Ref: LAN5124P
Date: 22 October 2025

Re: Morgan and Morecambe Offshore Wind Farms Transmission Assets DCO Examination
BAE Systems (Interested Party Ref: 20053944) Deadline 6 Submissions

This letter contains BAE Systems' Deadline 6 submissions for the Morgan and Morecambe Offshore Wind Farms Transmission Assets DCO Examination. It contains:

**Figure 1.6: Permanent mitigation area south of Newton-with Scales**

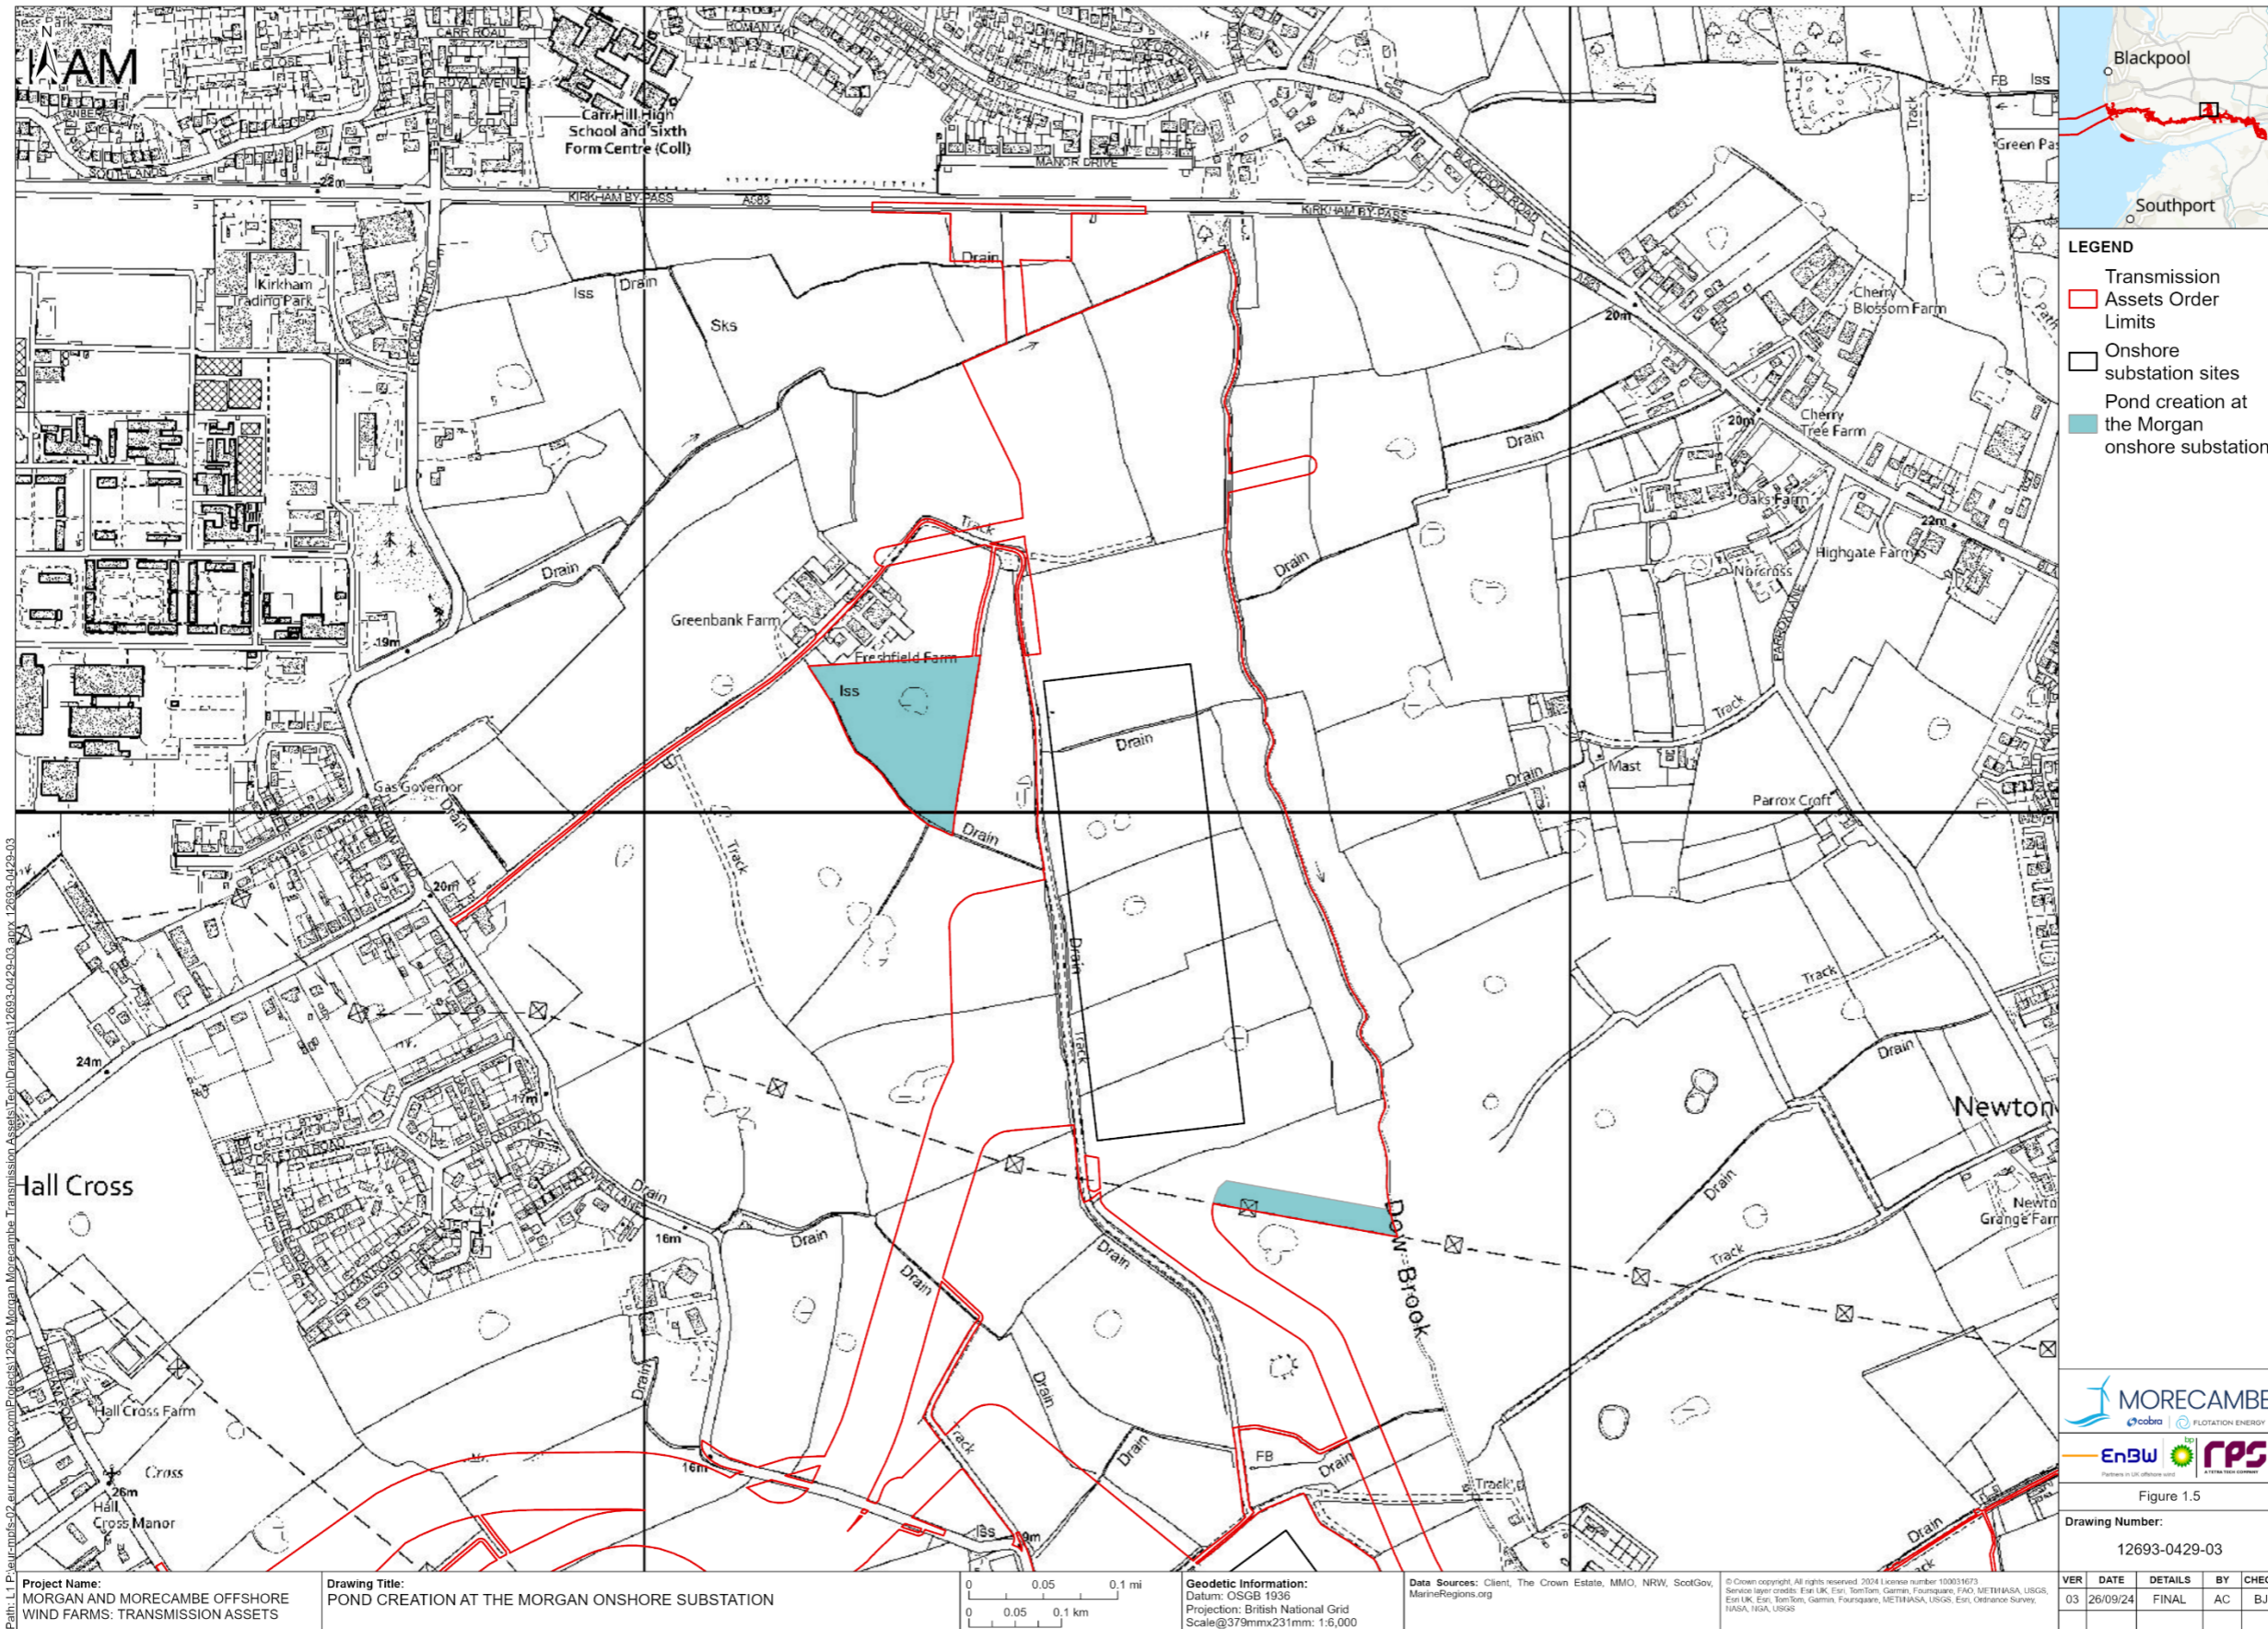
Following an initial review, of the draft WAHRA by the MOD's / DIO's SME, comments were fed back to the Applicants in a meeting on 17 October 2025. Those comments raised concerns relating to the location of the Newton-with-Scales ecological mitigation site. Following discussion and comments from the Applicants at the 17 October 2025 meeting, DIO agreed to seek clarification of certain matters from the SME and to obtain formal feedback on all of the Ecological Mitigation Sites, as well as the Biodiversity Benefit Site at Lea Marsh Fields. We understand that the DIO intends to update the ExA on the latest discussions with the SME at Deadline 6.
